Our Case Number: ABP-316178-23

Re: Proposed development of Oweninny Windfarm Phase 3 consisting of 18 no. wind turbines.
Within the townlands of Laghtanvack, Croaghaun (also known as Croaghaun West), Moneynieran, Corvoderry, Shanvolahan, Dooleg More, Shranakilly, Bellacorrick and Shanvodinnaun, Co. Mayo.

Please be advised that the Board, in accordance with section 37(F)(1) of the Planning and Development Act 2000, as amended, hereby requires you to furnish the following further information in relation to the effects on the environment of the proposed development: .

Overview Sheet

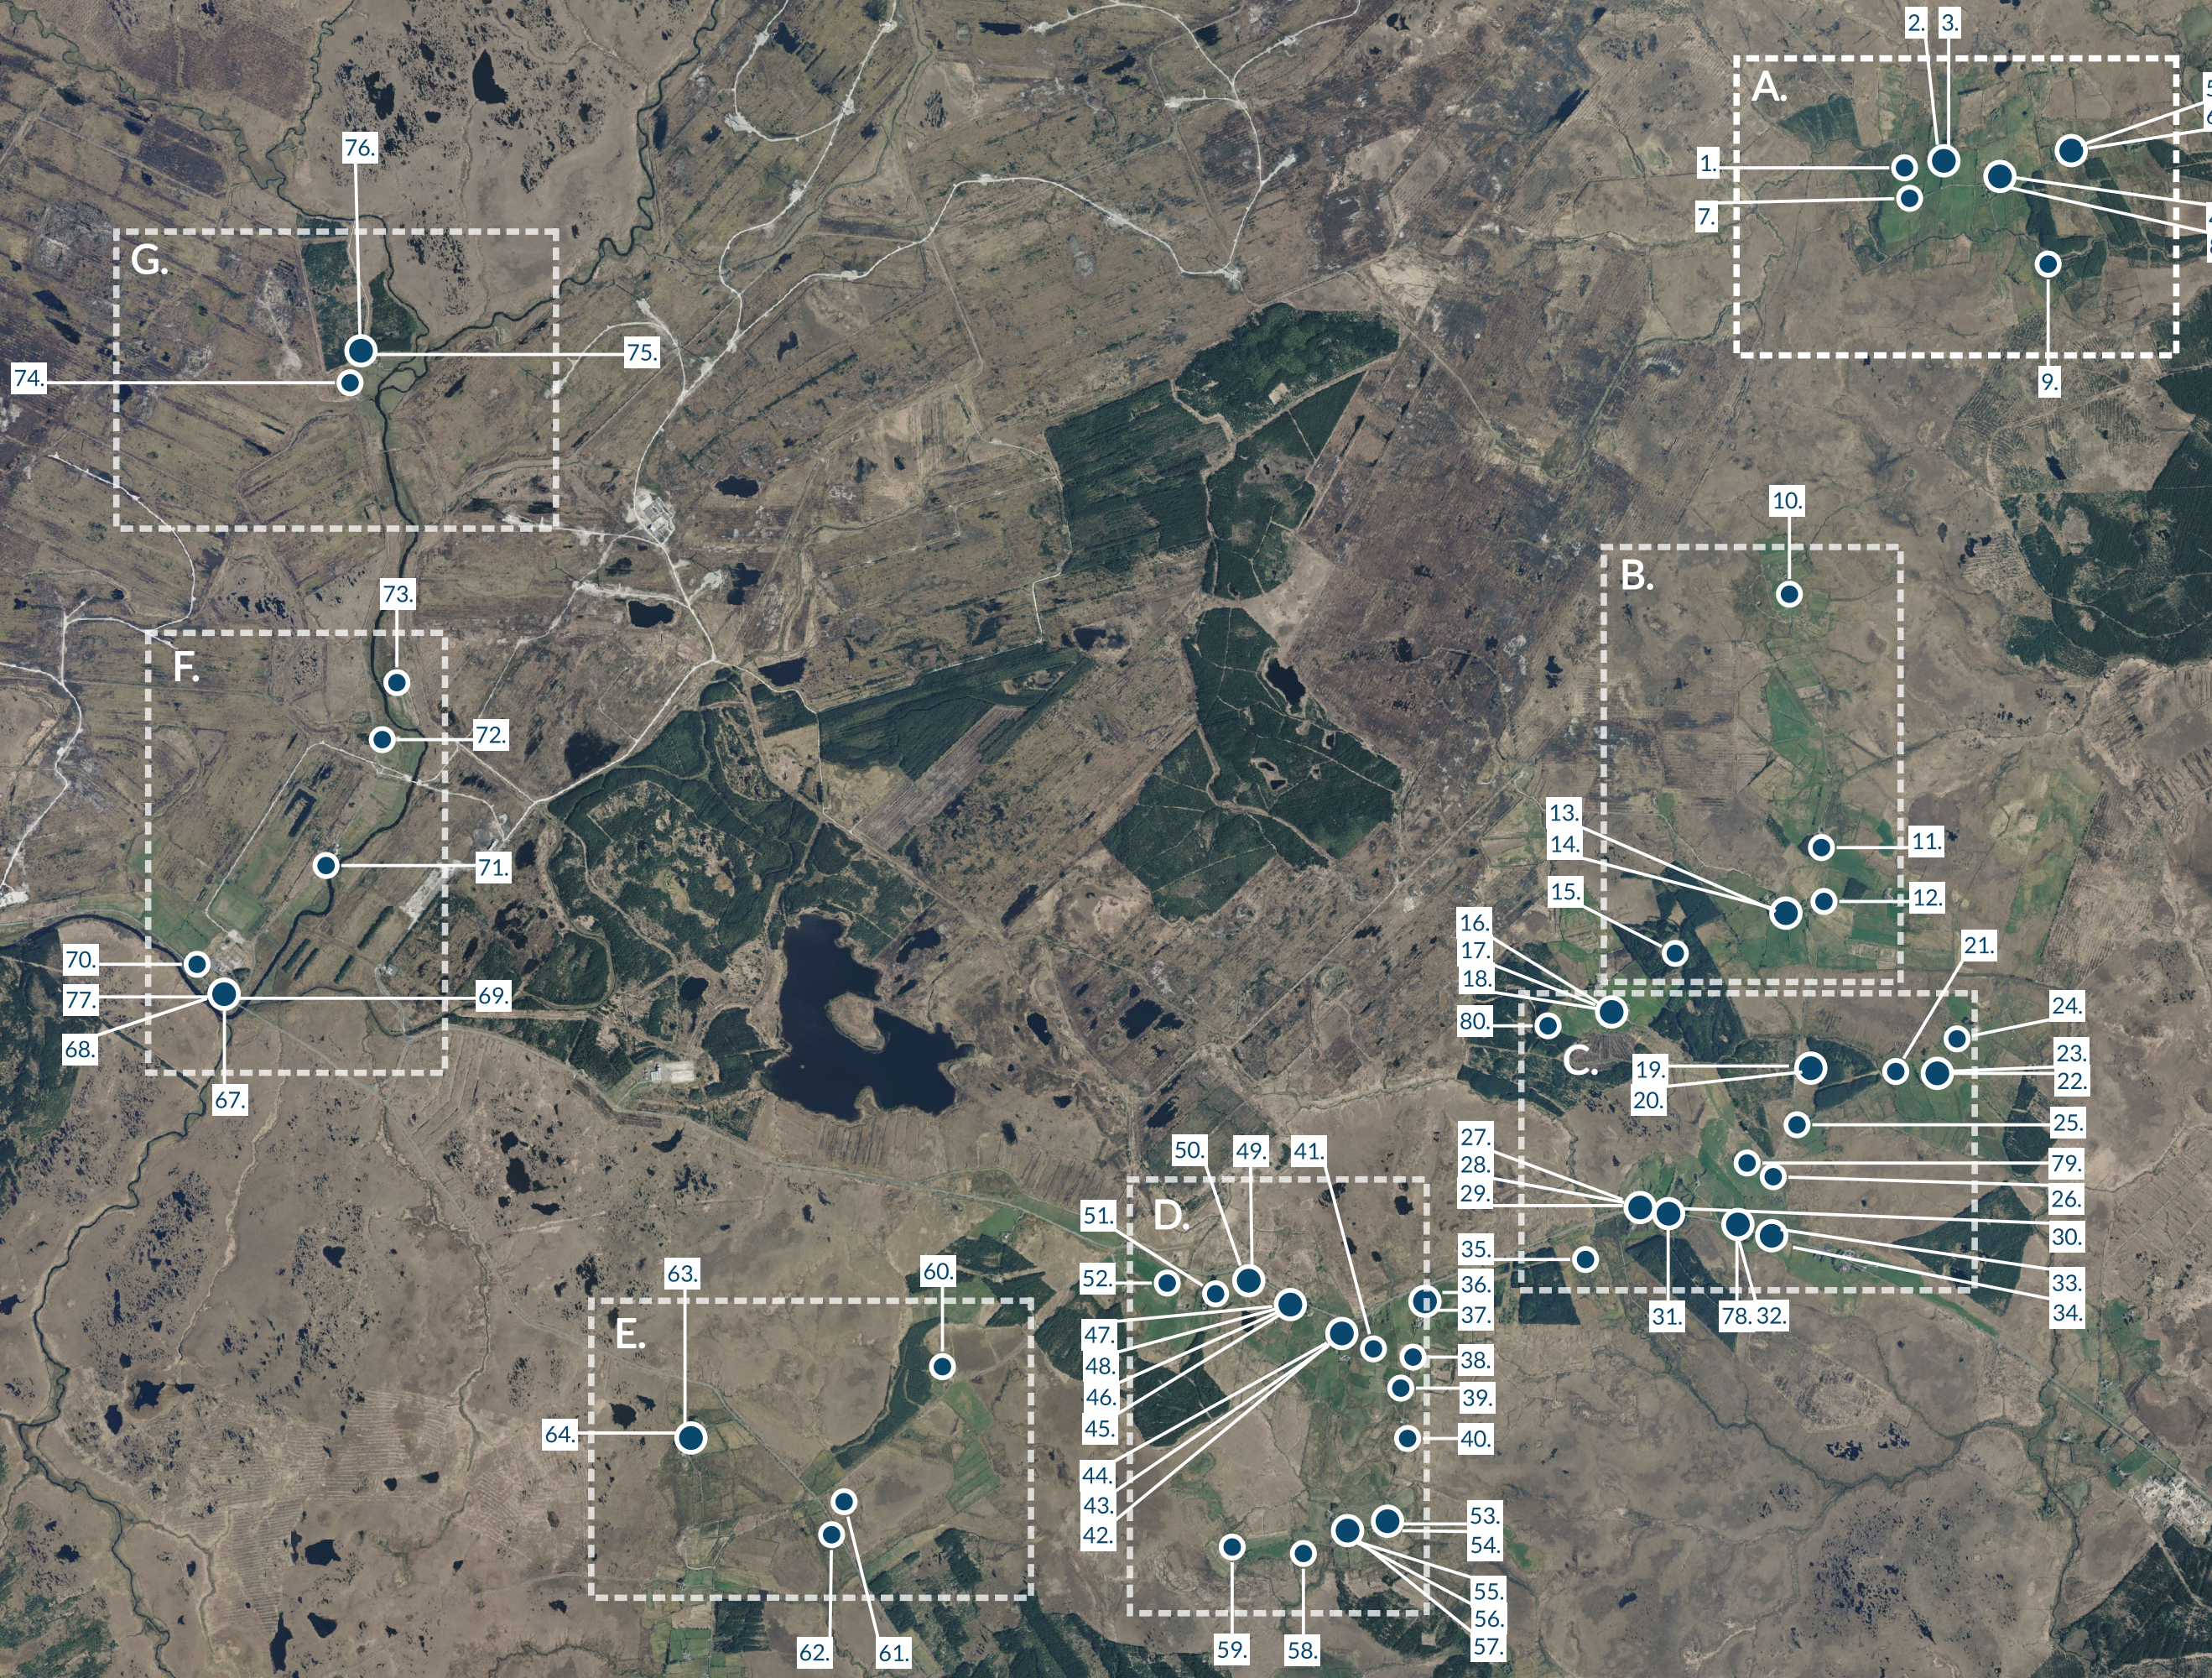
1. Site Layout Plan: Submit a site layout plan which indicates the location of existing structures and development on site, including turbines and access roads. The site layout plan shall also indicate the turbines and access roads of adjoining windfarm developments such as Phase 1 and Phase 2 Oweninny windfarm. Annotate and label the turbines (both on and off site). Indicate the extent of existing access track to be retained as part of the proposed development.
